**Re: Hartman Publishings, 1313 Iron Ave SW, Traffic Circulation Layout  
Architect's / Engineer's Stamp NOT dated (K13-D045)**

Based upon the information provided in your submittal received 1-14-14, the above referenced plan cannot be approved for Building Permit until the following comments are addressed:

1 Traffic Circulation Layout - TOL
1" = 10'-0"

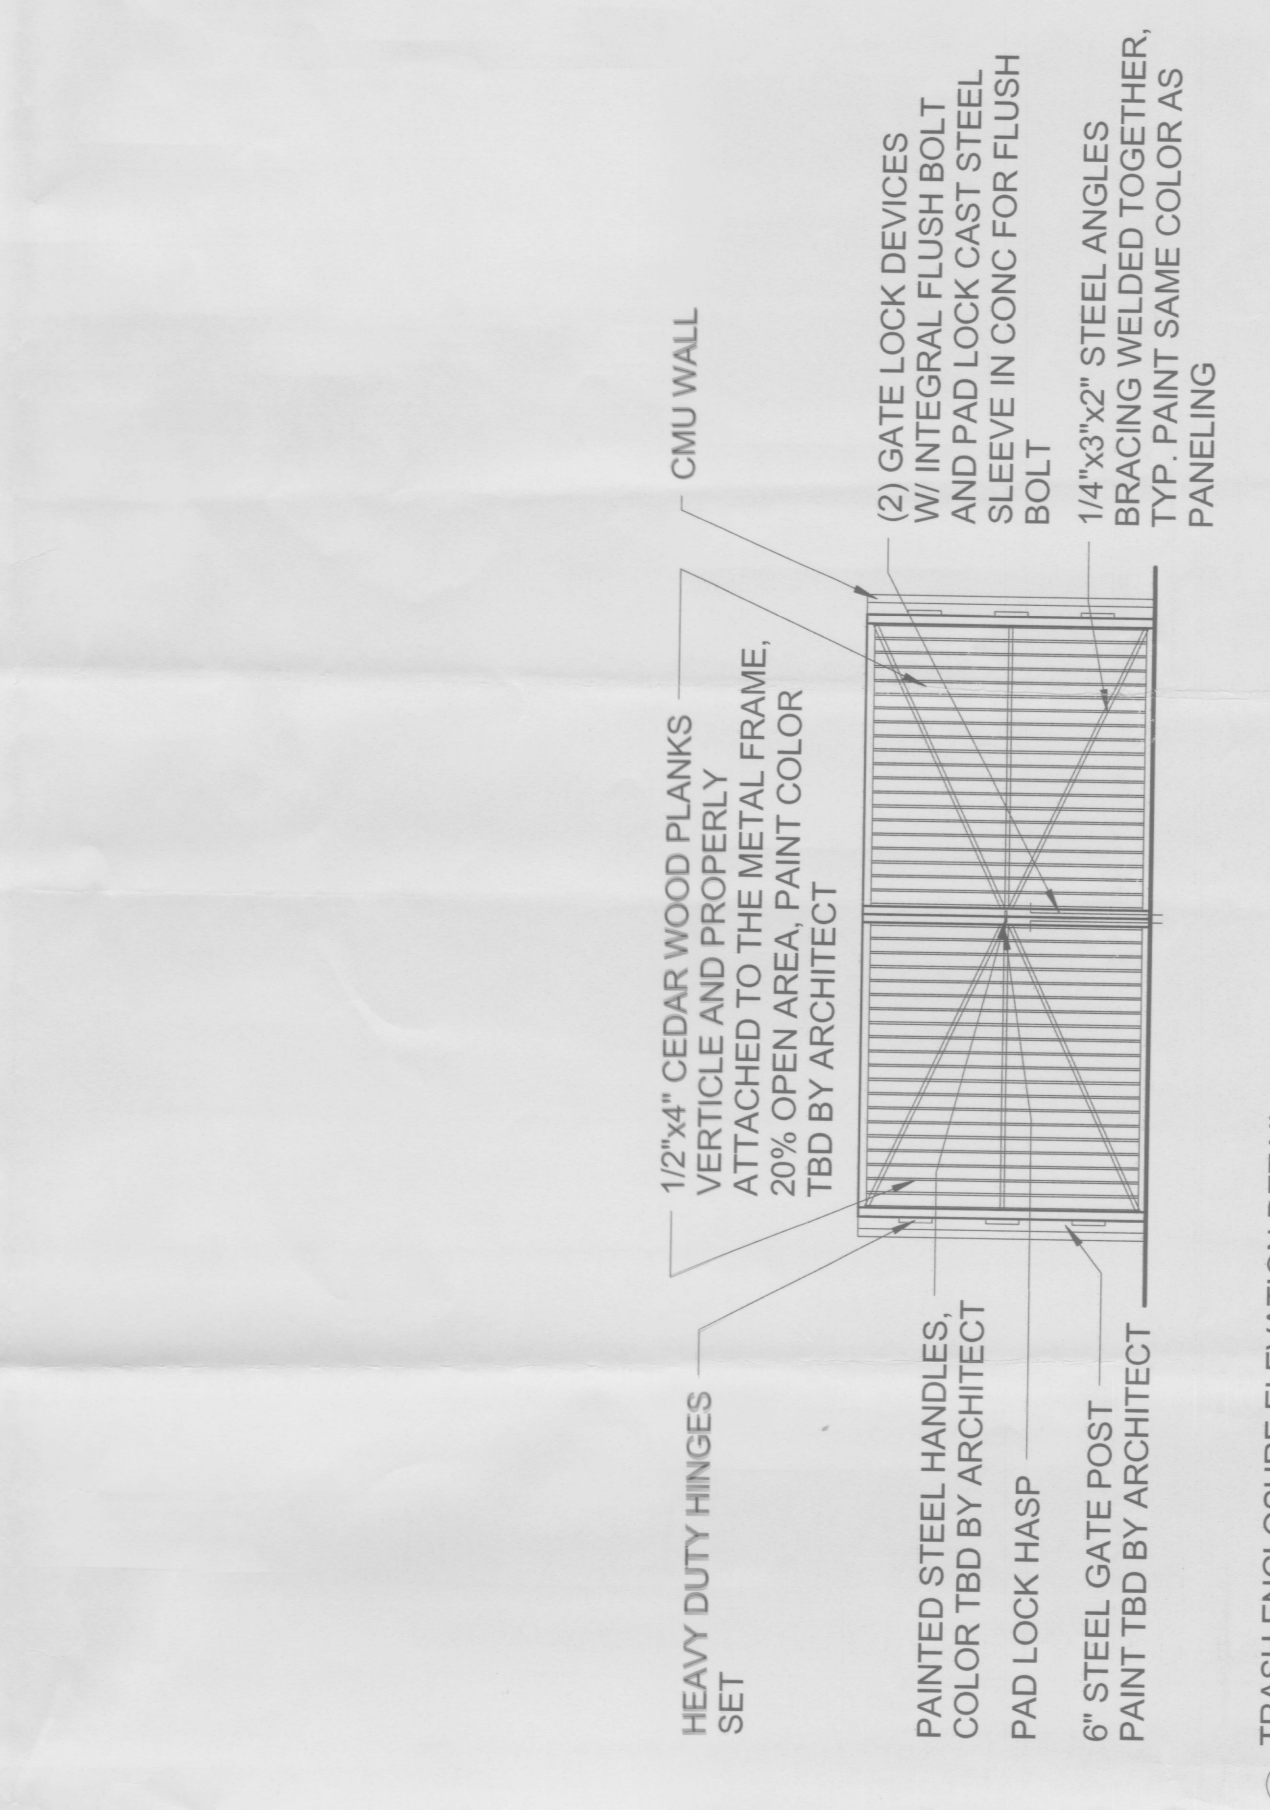
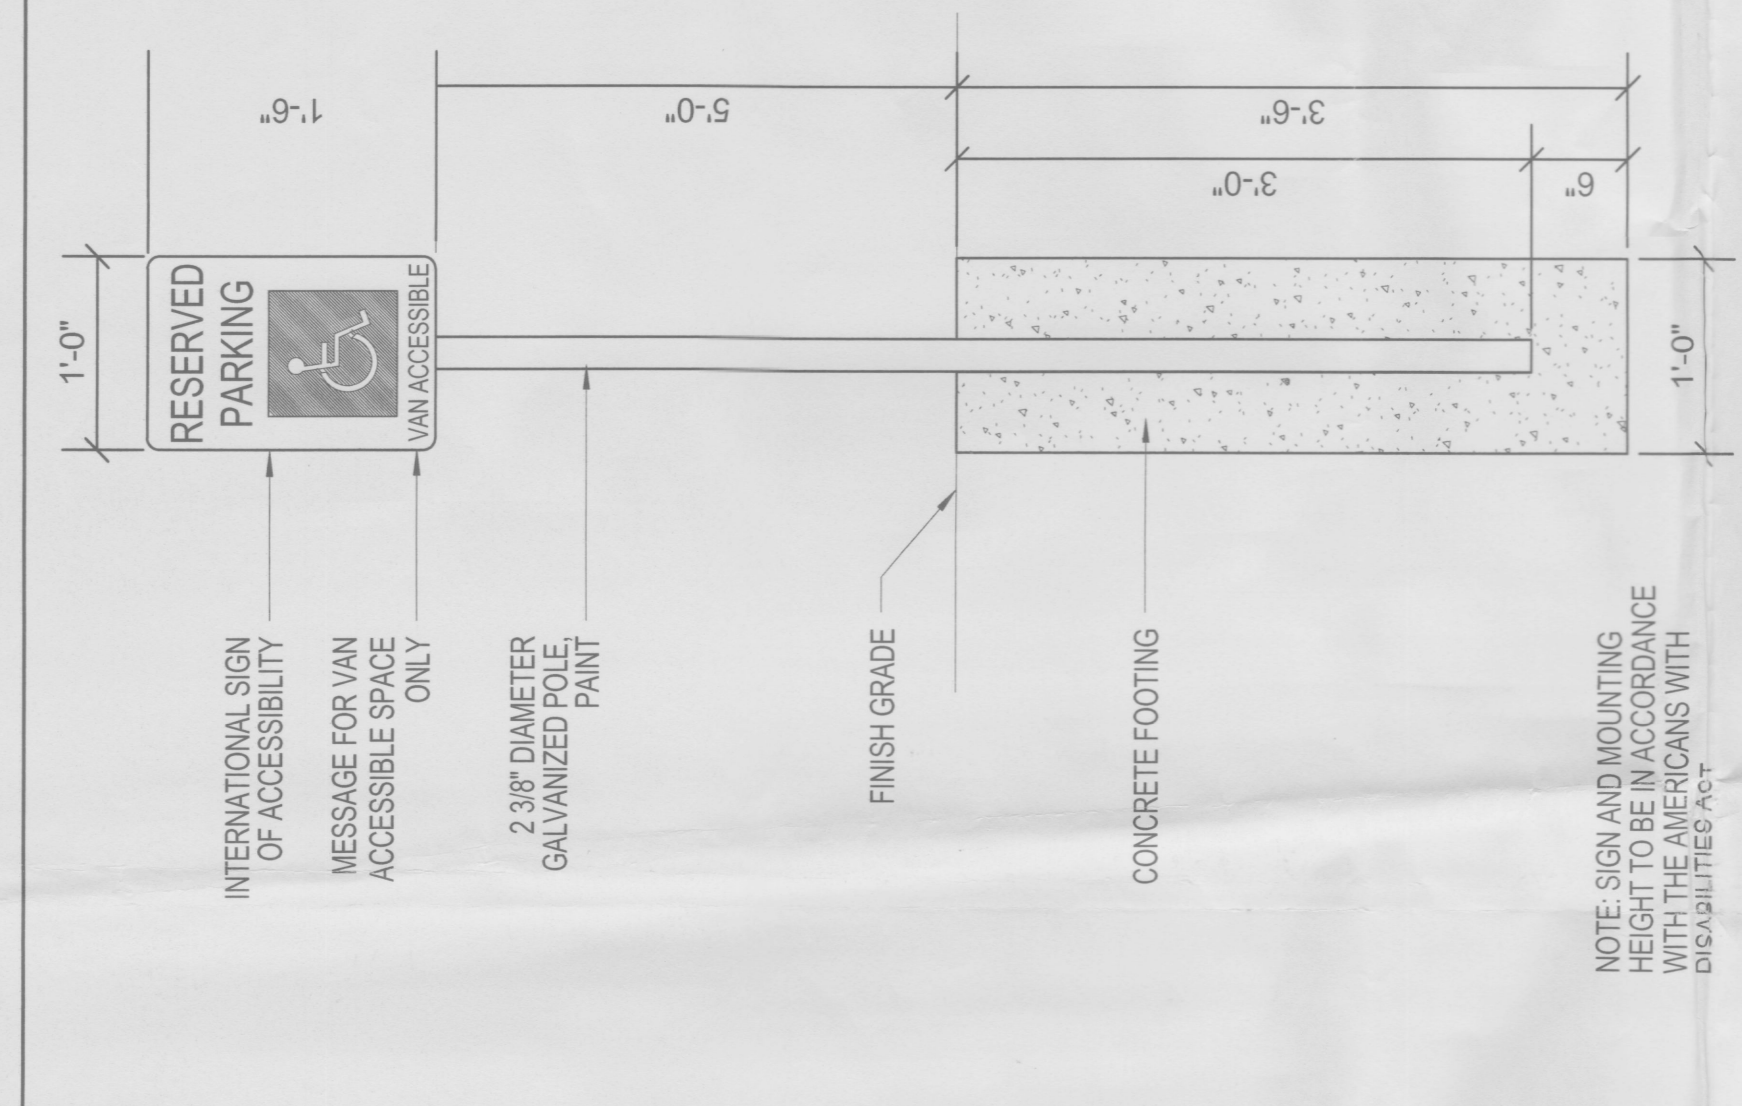
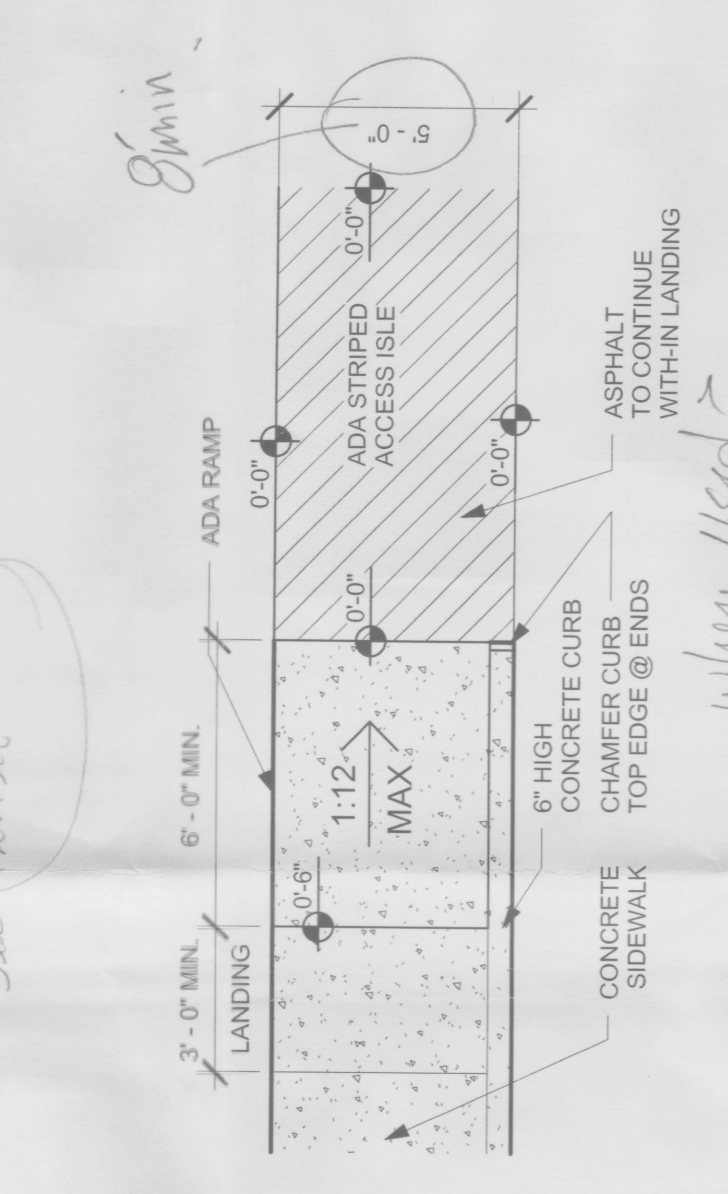
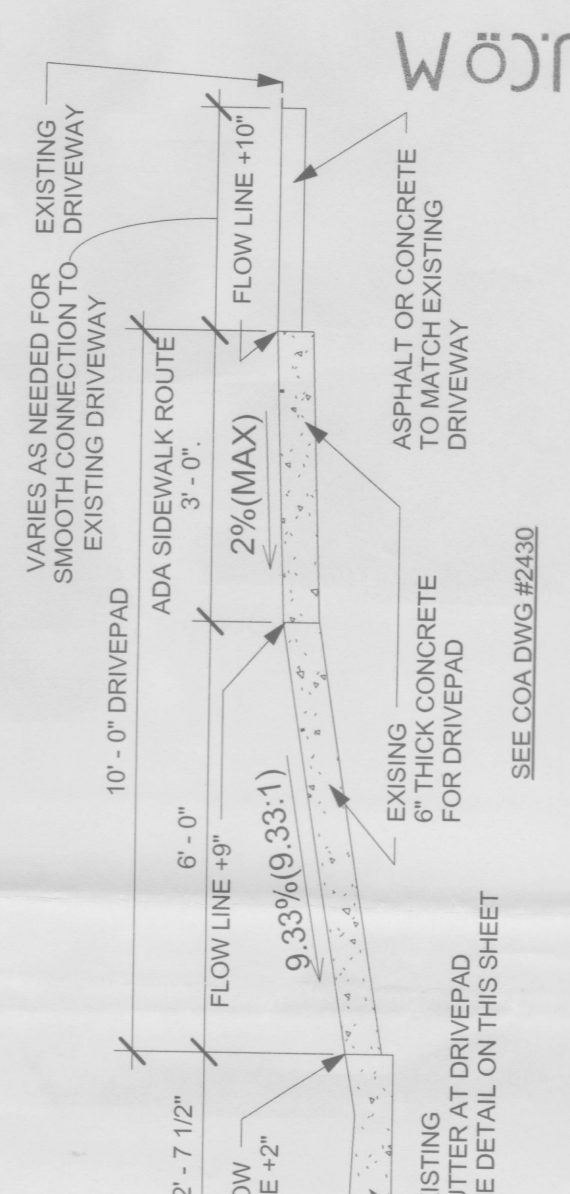
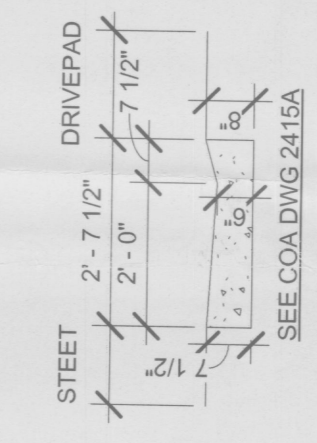
1. List radii for all curves shown; for passenger vehicles, the minimum end island radius is 15 feet, see the *DPM Ch 23, Section 7, Part B.2 Treatment of Access Points*.

2. The development of this site must be in compliance with current DPM and ADA standards and regulations.
3. Per the DPM, a 6 ft. wide ADA accessible pedestrian pathway is required from the public sidewalk to the building entrances. Please clearly show this pathway and provide details.

4. Per the DPM, a 6 ft. wide ADA accessible pedestrian pathway is required from the HC parking stall access aisles to the building entrances.
5. Provide details of Keyed note I for ADA ramp. Diagonal line type labeled in legend for new concrete is not used.

6. Provide details of Keyed note K.
7. Clarify the ADA Ramp Detail 3 provided on TCL, existing or proposed, and application?
8. The existing steel fence may interfere with the sight distance of the intersection on Iron Ave and 14<sup>th</sup> St. Please provide a sight distance exhibit (see the *Development Process Manual, Chapter 23, Section 3, Part D.5 Intersection Sight Distance*).

9. Is landscaping required by zoning? If so, please provide landscaping plan with next submittal. Per the *Development Process Manual*, Chapter 23, Section 7, Part B.6, curbing should be used to separate landscaping from parking areas and pedestrian ways as well as providing a physical perimeter for harvesting water. This must be clearly shown on the TCL.
10. Please add the following note: "Landscaping and signing will not interfere with clear sight requirements. Therefore, signs, walls, trees, and shrubbery between 3 and 8 feet tall (as measured from the gutter pan) will not be acceptable in this area."
11. Please refer to details below for current ADA compliant signage:

Built-up curb ramps shall not extend into the accessible parking space or access aisle.  
ANSI 502.5 and ADAAG 4.6.3 2010 Standards

13. The traffic circulation layout must be stamped, signed, and dated by an engineer or architect licensed in the state of New Mexico.
